Application No: EP/69/21/PL
Site Address: 4 Beechlands Close and east of 18 Beechlands Court Montpelier Road East
Preston BN16 1JZ
Description of works: 1 No. 3-bed bungalow (resubmission following EP/10/21/PL). This site is in CIL
Zone 4 & is CIL Liable as new dwelling.

Thank you for your internet representation made on 26th July 2021 which has been recorded as an objection with the comments as follows:

SITE PLAN

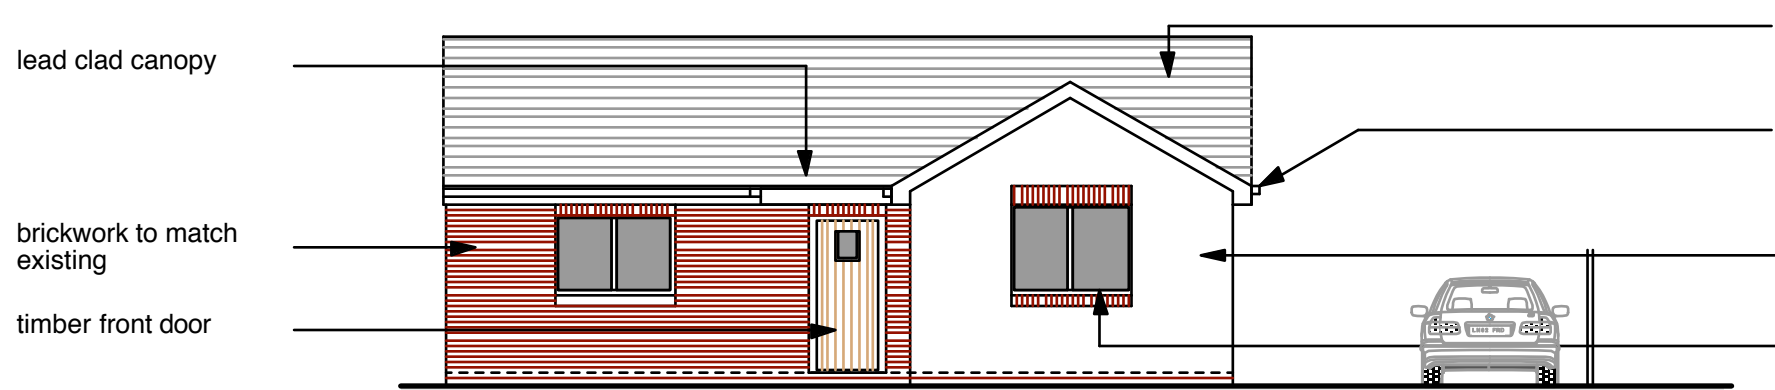
Congestion due to single road access during and after construction
Lack of parking, the road is already over parked and the access will take one space away
The property is built right onto the pavement which is out of keeping in the area
